**CITY OF PORTLAND, MAINE**

**SITE PLAN REVIEW**

2326-2340 Congress Street

I am writing to pass along some staff concerns about the Excess Insurance site on outer Congress Street. The plan has been reviewed by Bill Bray, City Traffic Engineer, and Bob Roy in Public Works.

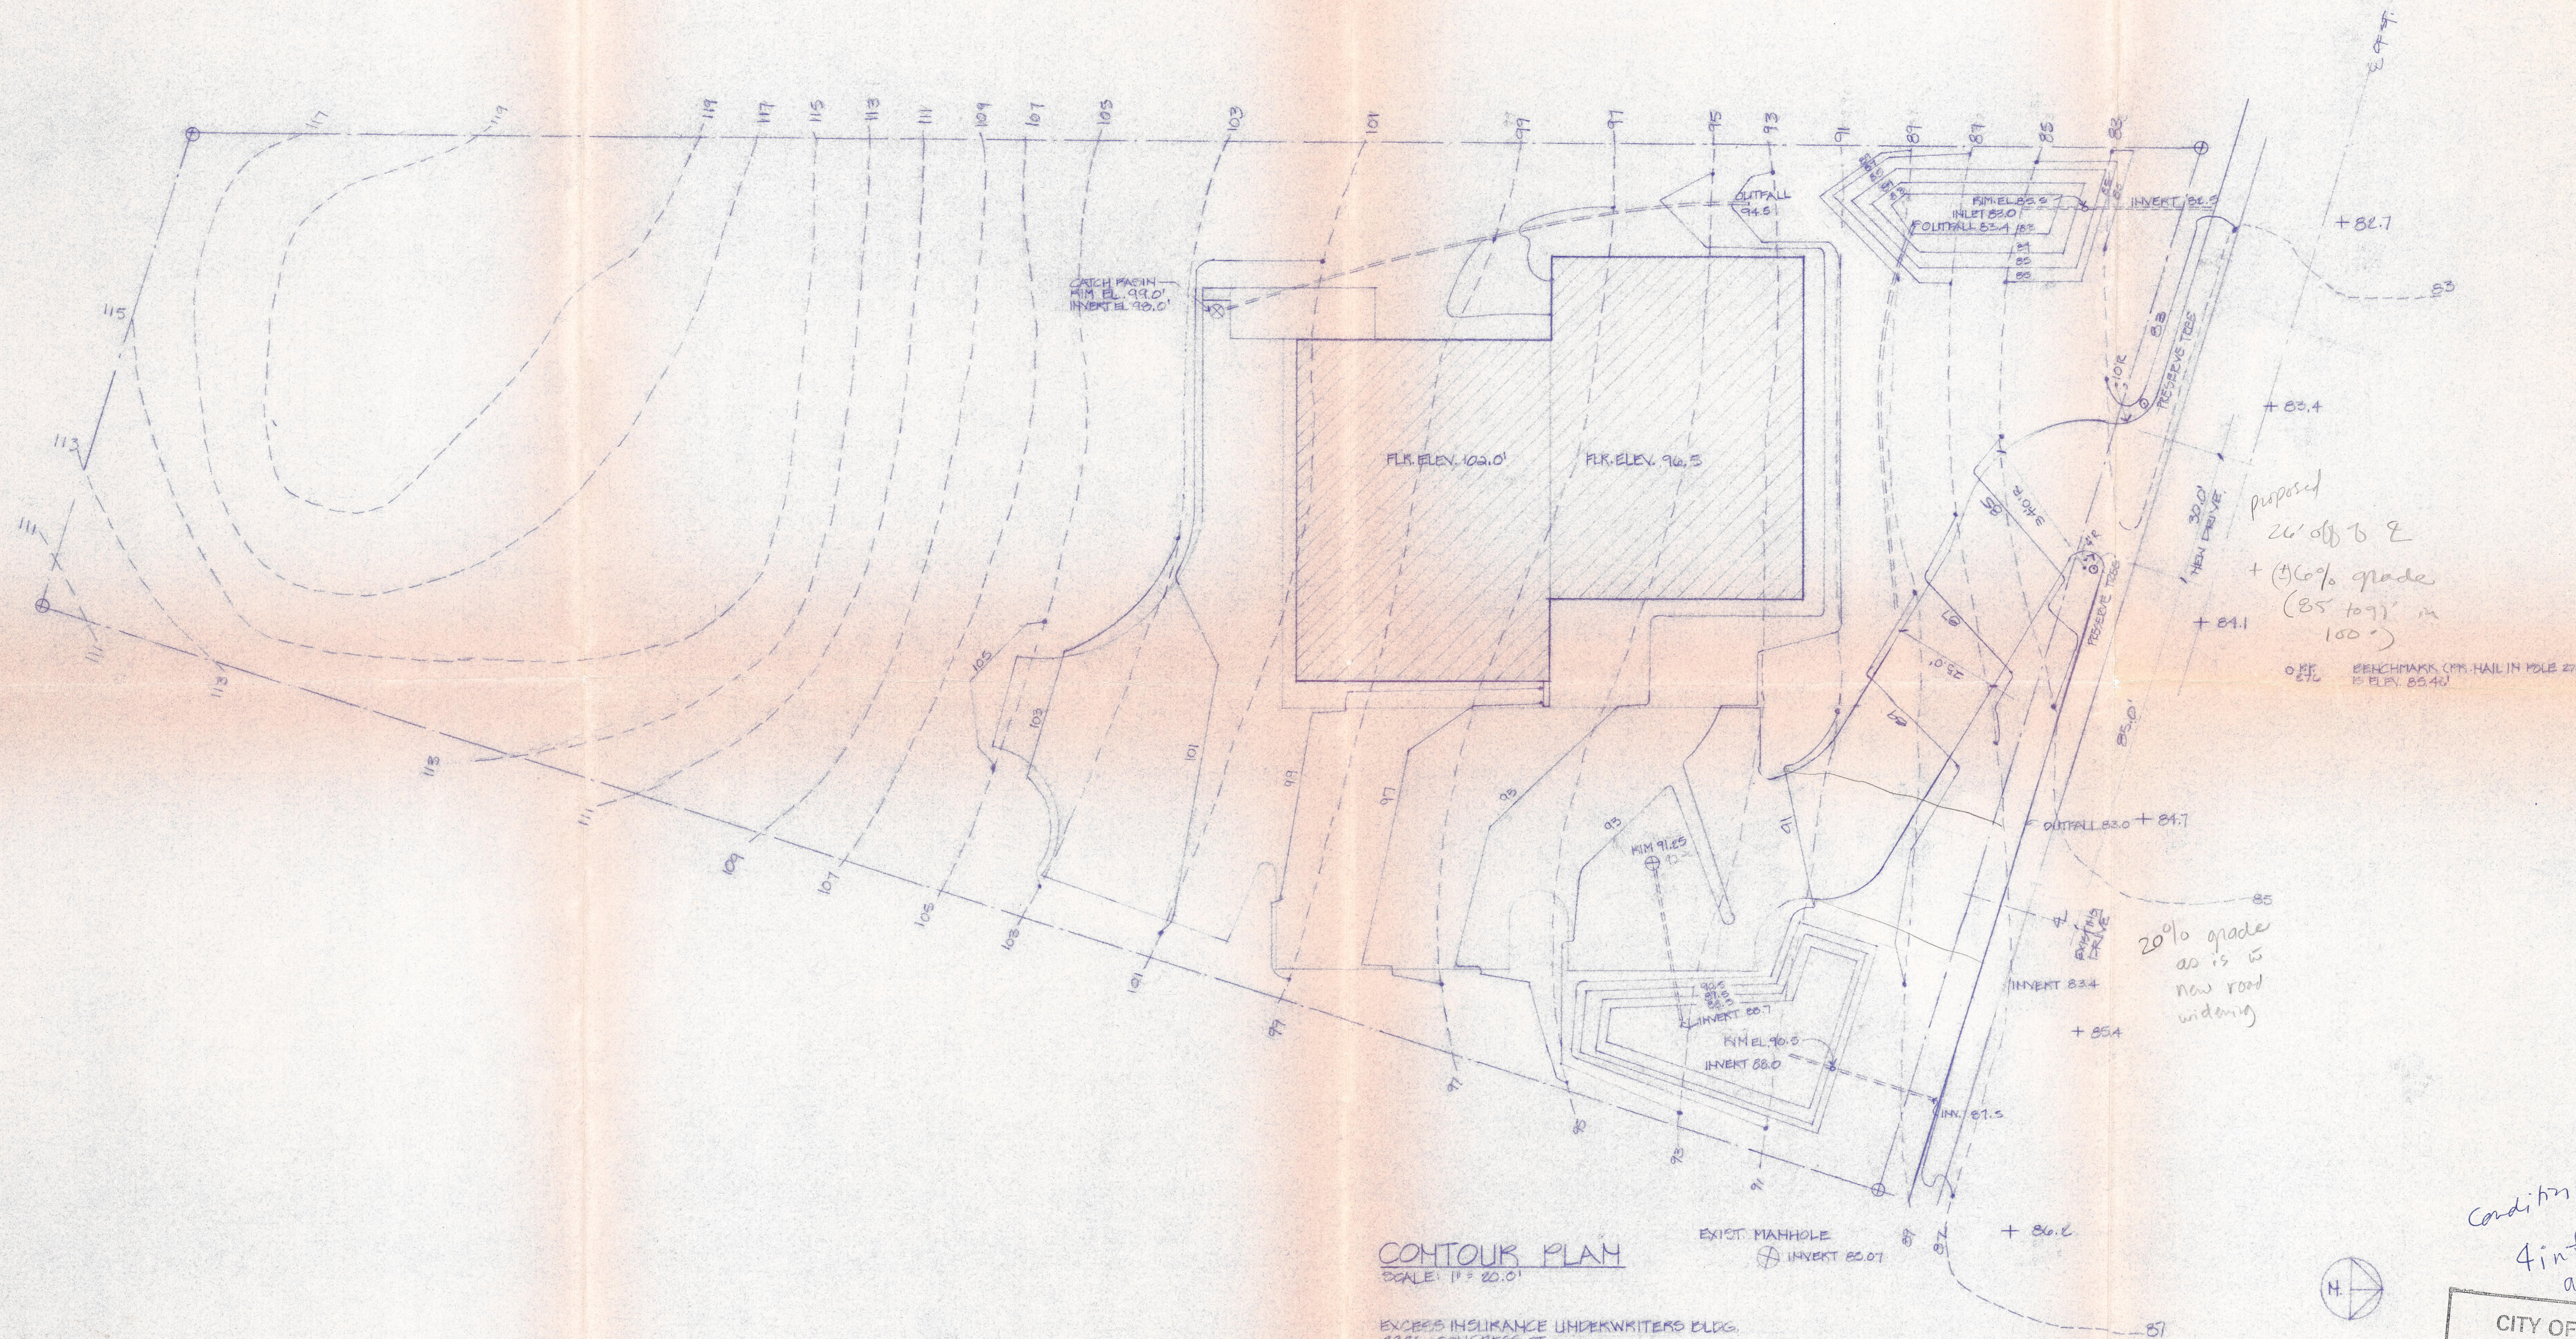
- Pavement along Congress Street should be widened to match the width of Congress at the Hutchins Street intersection. Minor tree trimming and removal may be required after the driveway is graded.
- Pavement to be tapered back to existing edge of pavement at the east side of property, using an 8 to 1 taper. Transition not to be curbed.
- Congress Street to be overlaid to centerline of street with a minimum of 1 1/2" overlay.

- contours and site grading elevations must be referenced to mean sea level ~~to mean sea level~~ datum.
- Detention basins shall be designed in accordance with city standards and also include
  - a) invert elevation of outlet pipes.
  - b) elevation of spillways
- Indicate size, invert elevation and type of material for driveway culvert.
- Need additional catch basin in ~~driveway~~ <sup>parking lot</sup>.
- Drainlines from catch basins shall be adequately sized. 4" is unacceptable.
  - a) Show catch basin invert elevations, pipe sizes and slopes.
- Size and location of water service.
- Documentation of right to connect into private sewer.

- Invert elevations at existing sewer manhole. Note sewer service size and slope. Need clean out at angle in line.
- Radius of curb at driveway?
- Erosion control measures are inadequate.
